Ribble Valley Borough Council
Housing & Development Control

Application no: **3/2022/0632**

Address: **Pendle Mill Pendle Road Clitheroe BB7 1JQ**

Proposal: **Demolition of existing buildings and erection of a care home (Use Class C2) of up to 70 beds. All matters reserved apart from access.**

Drawing Title
Proposed Site Plan with Topographical Survey

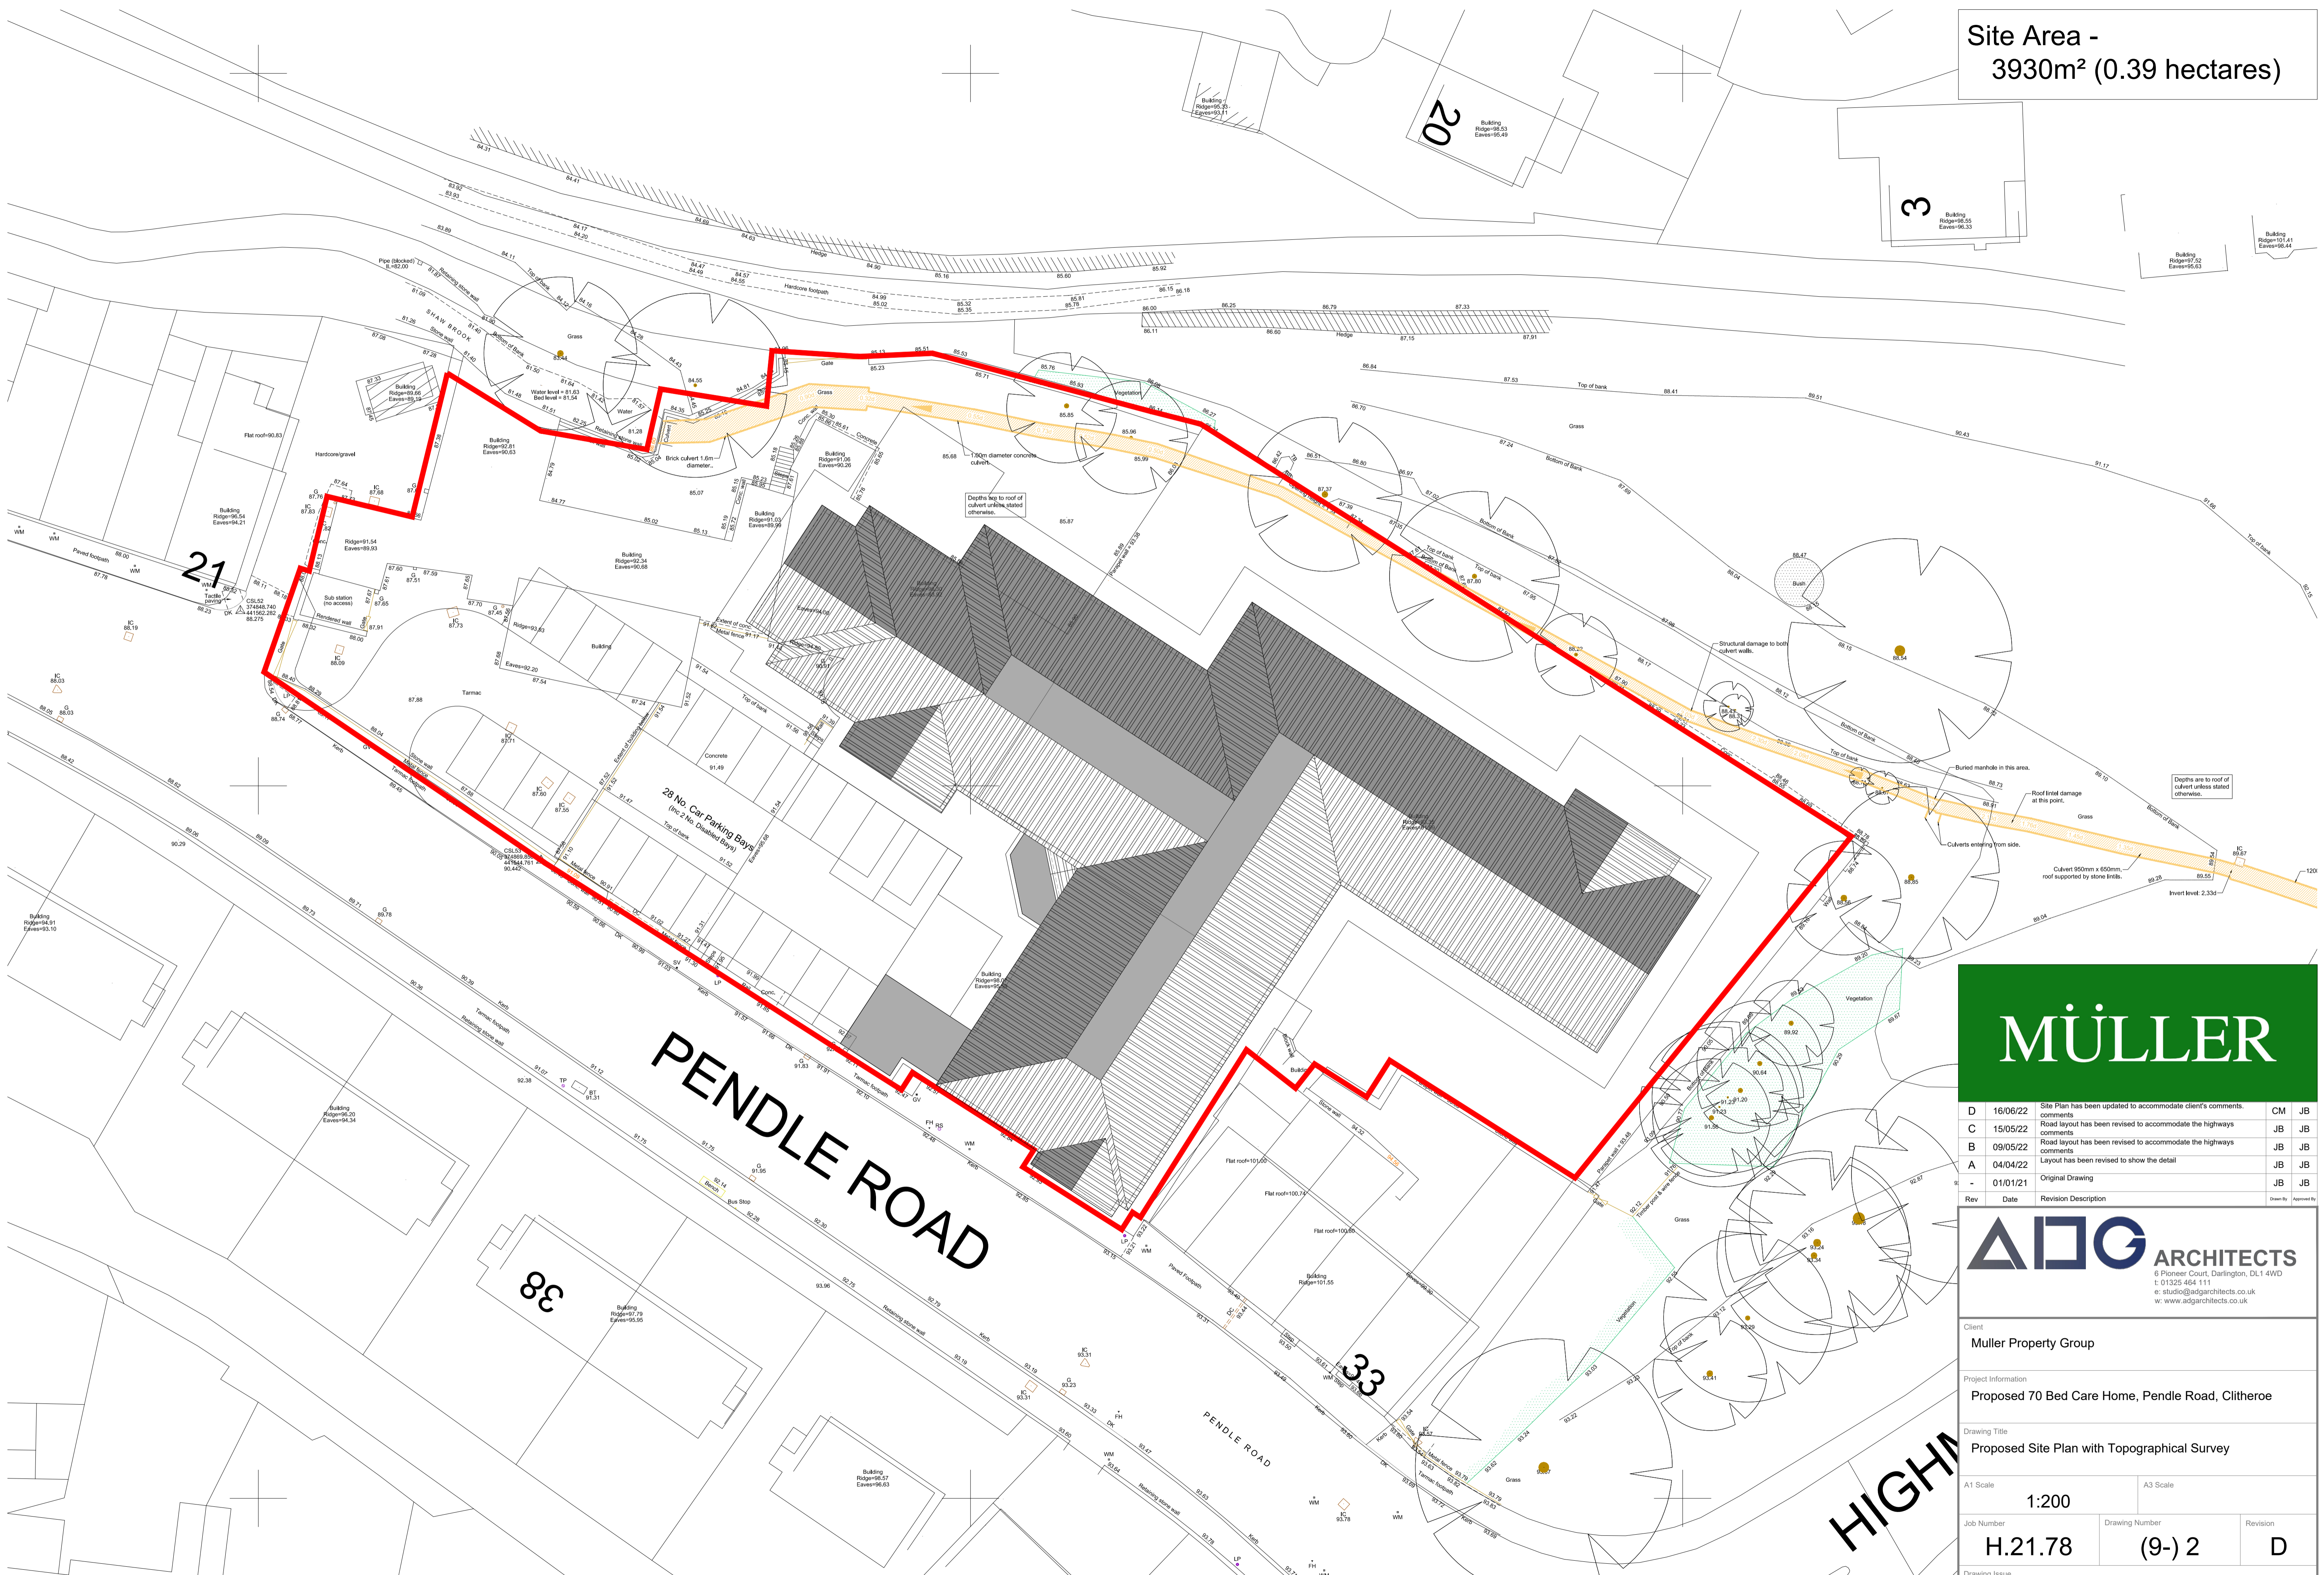
Furthermore, the LHA are aware that the proposed access may conflict with the existing streetlight on Pendle Road. To ensure that the access does not conflict with the streetlight, the LHA require a revised drawing showing the location of the streetlight. The LHA inform the Applicant and Agent that should the access conflict, the Applicant will be liable to relocating the streetlight elsewhere.

The LHA have reviewed the tracking drawing and are aware that the bodies of the vehicles are quite close together when two-way movements are occurring at the access due to the curve of the internal road. To ensure that no collisions occur at the

access when two-way movements are occurring, the LHA will require the junction radii to be a minimum of 6m. This should be shown on a revised drawing. To further ensure the junction radii is adequate a revised tracking drawing of two vehicles should also be submitted.

Furthermore, to ensure the width of the access is adequate the LHA will require a tracking drawing of a refuse vehicle entering and exiting the site access is submitted. The LHA will require this because the LHA are unable to accept a servicing area for the site to be provided on-street along Pendle Road. This is because, while its likely servicing currently occurs on-street to serve the furniture company, a more formalised area internally is required for the care home. The formalised area can then be used by emergency vehicles and minibuses as well.

However, and again this can be addressed during the reserved matters stage, but the LHA advise that the parking space located in the visibility splay to the left of the access is realigned so that it is line with the first 4 spaces. This is because currently should a vehicle be parked in this space it will obstruct the accesses visibility.

It is worth noting that the LHA welcome the proposed tactile paving which will be provided at the site access, as shown on the drawing. However, the LHA will request that tactile paving is provided on the proposed 2m wide footway which will be provided to the right of the access across from number 21 Pendle Road. This is to align with the tactile paving provided on the existing footway adjacent to the dwelling.

However, given that 23 staff members will be on site at any one time and 14 spaces are required for the residents, the LHA require 37 spaces to be provided. Therefore, there is a shortfall of 9 spaces.

The LHA are requesting further car parking spaces are provided to ensure that there is adequate parking spaces during shift changes and there is a minimum of one space per member of staff on site at any one time. More capacity is required to ensure that there is adequate number of parking spaces during visiting times for the residents. This is so that inappropriate parking does not occur on the highway.

Furthermore, as discussed in the site access section, the LHA require an internal servicing area to be provided for refuse, service and emergency vehicles. This is because the LHA are unable to accept the proposed servicing area which is located on-street along Pendle Road, as shown on Sanderson drawing number 300828-002 titled "Proposed Servicing Arrangements."

To complement an internal servicing area, which should be shown on a revised plan, a turning head should be provided ensuring that large vehicles can exit the site in a forward gear. The suitability of the turning head and the internal carriageway should be supported by a swept path analysis drawing showing a refuse vehicle entering and exiting the site in a forward gear.
